Morecambe Offshore Windfarm: Generation Assets Development Consent Order Documents

Schedule of Changes to the Draft Development Consent Order (Rev 05)

Document Reference: 3.4

Doc No	FLO-MOR-GIS-MAP012-Protective Provisions-Rev001	Rev	02
Alt Doc No	n/a		
Document Status	Approved for Use	Doc Date	11 March 2025
PINS Doc Ref	3.5	APFP Ref	n/a

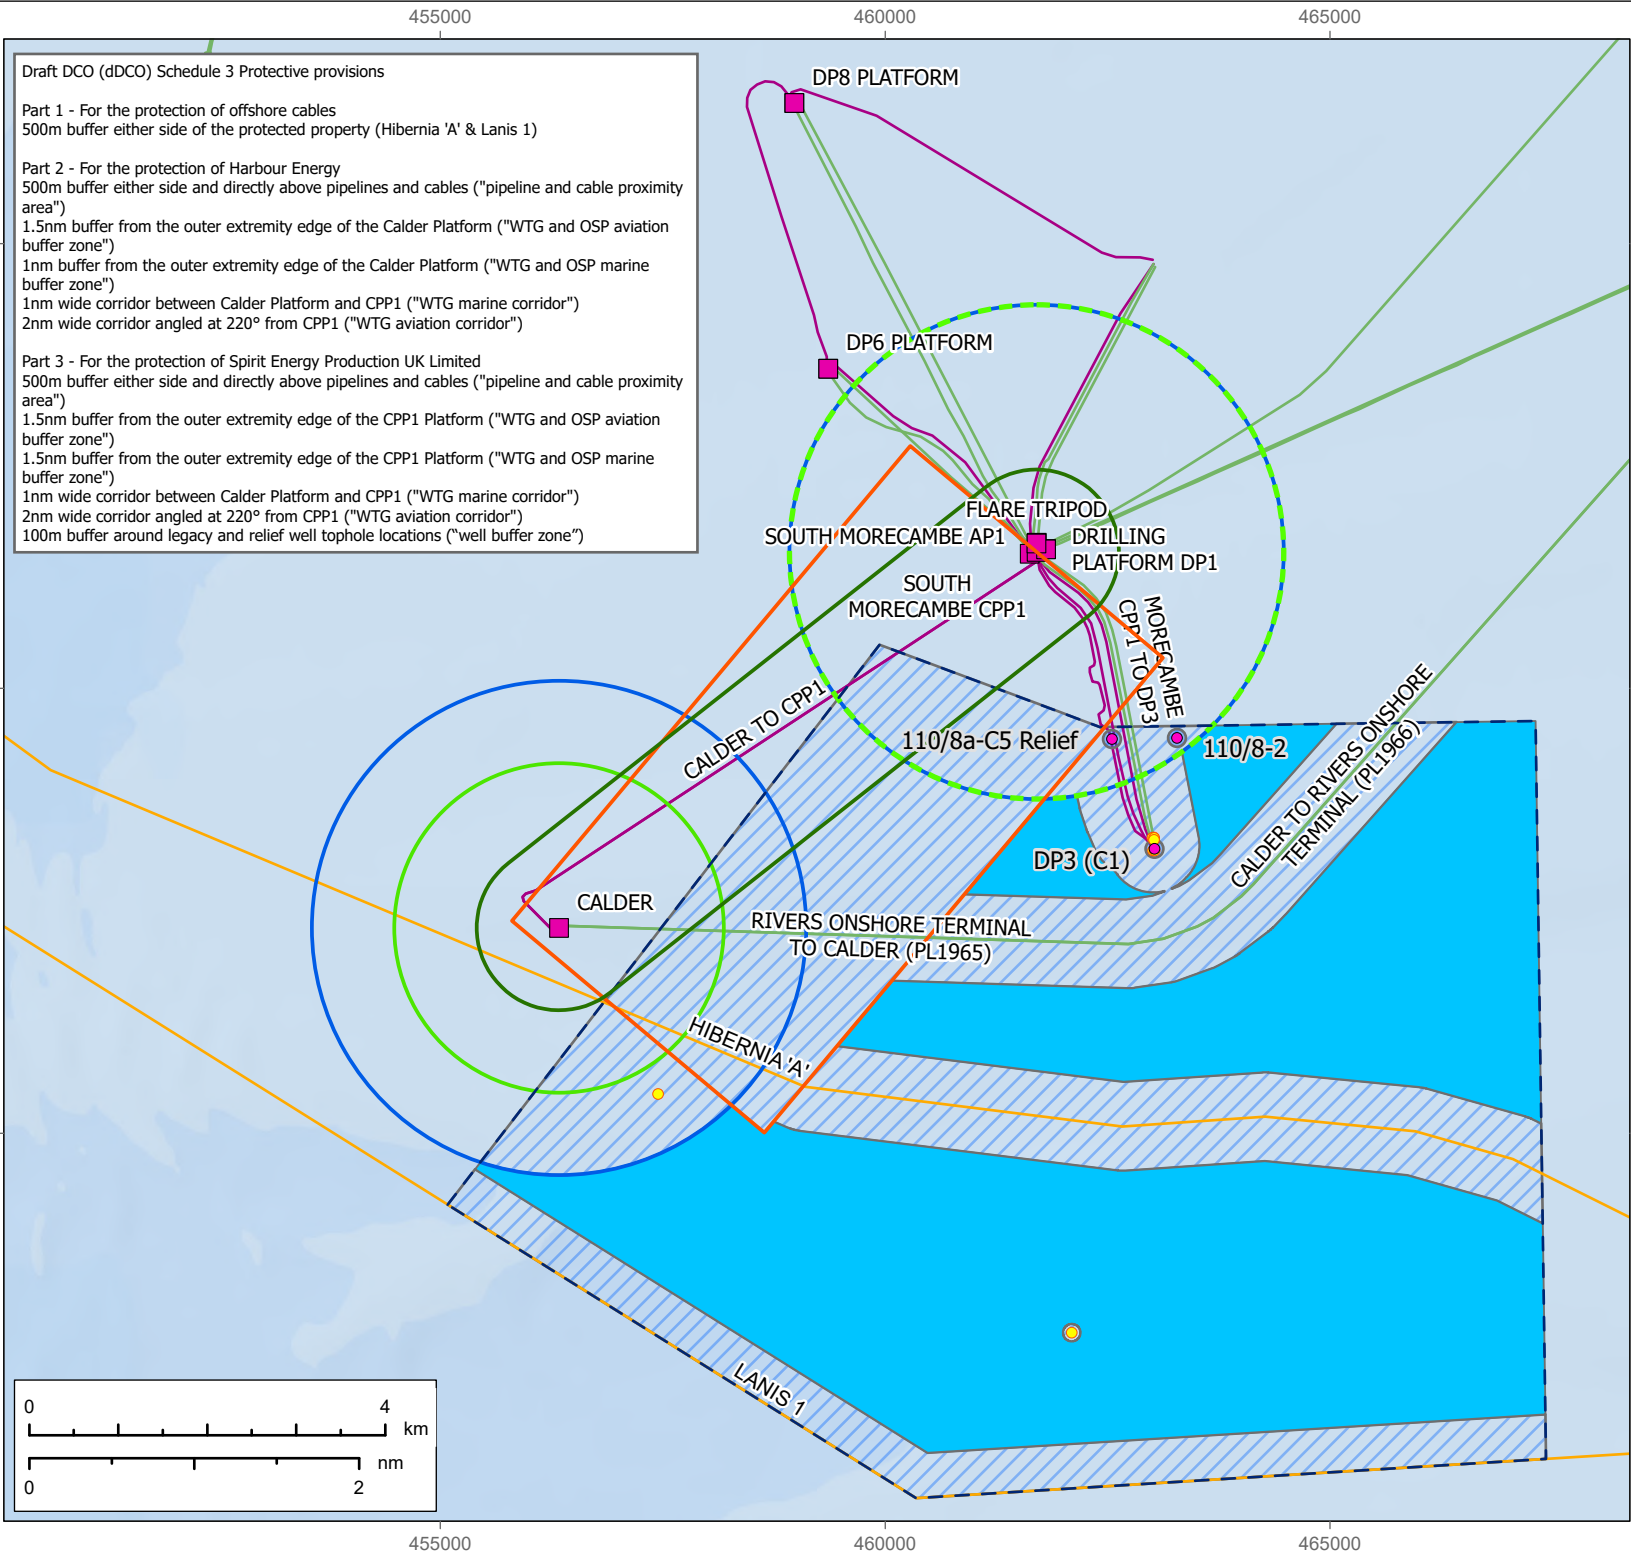
Schedule 3 (Protective provisions)	Part 1 for the protection of offshore cables has been updated.	To include reference to the protective provisions plan showing the location of the offshore cables.
Schedule 3 (Protective provisions)	Part 2 for the benefit of Harbour Energy has been updated.	Following discussions with Harbour Energy, although the Applicant notes that discussions between the parties on the final form and content of these protective provisions are ongoing.
